## CONSULTEE RESPONSE (Council's Arboriculturist)

**Reference:** FP/154/25/T

**Location:** 9 Innerwyke Close, Felpham, PO22 8PY

**Proposal:** Reduce height to leave 9m, reduce north side to leave 2.5m and reduce west side to leave 2.5m to 1no. copper beech.

Figure 2 Positions of final cuts

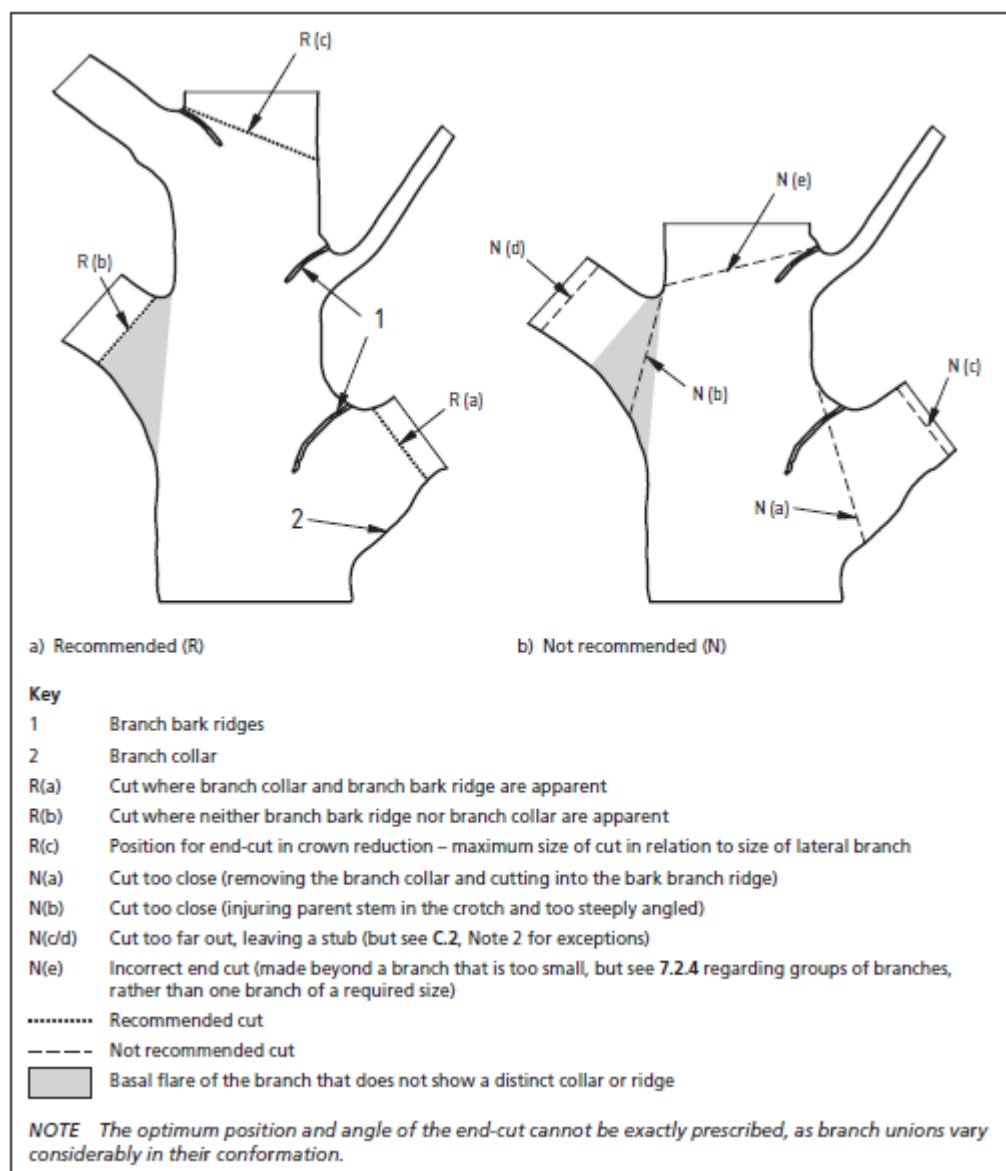
Part a) Where whole branches are to be removed and final cuts made close to the trunk or branch union they are to be made as shown in Figure 2 of BS3998:2010

Part b) Where branches are to be shortened back the final cuts are to be made at the correct angle shown in BS3998:2010 and adjacent to a live bud or lateral.

Figure 3 Crown lifting

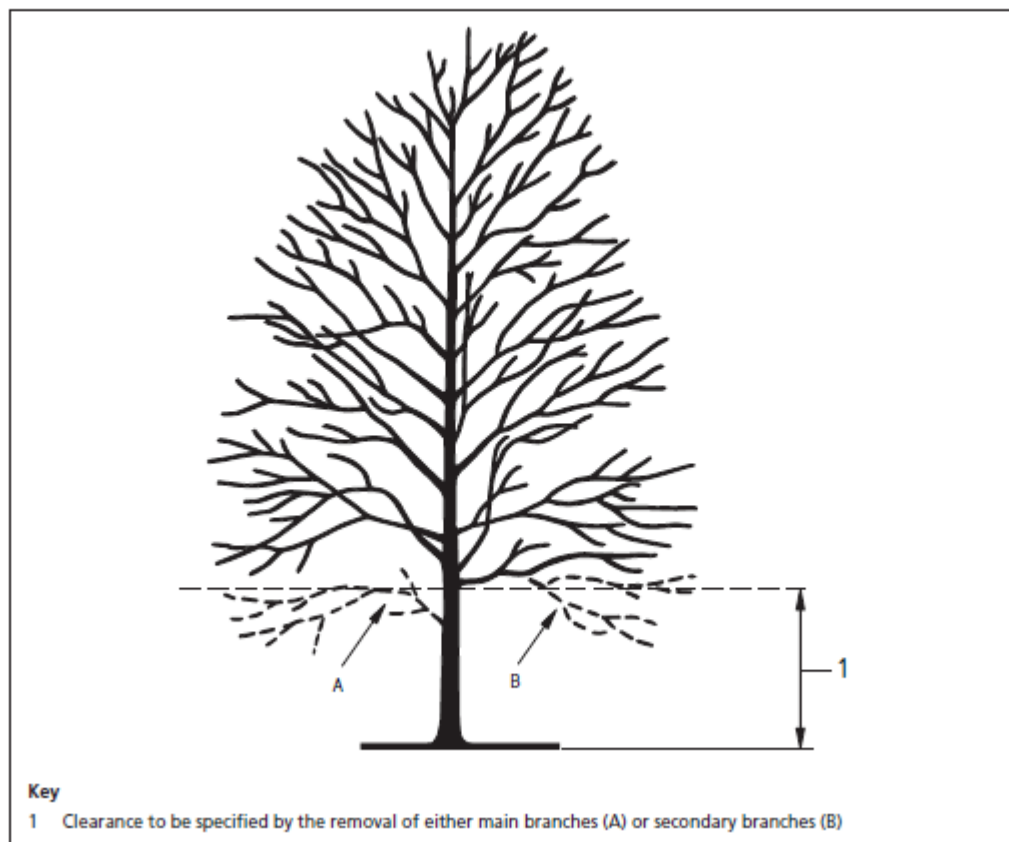
- Crown lift to provide a maximum overhead clearance of 3.5metres on all aspects.
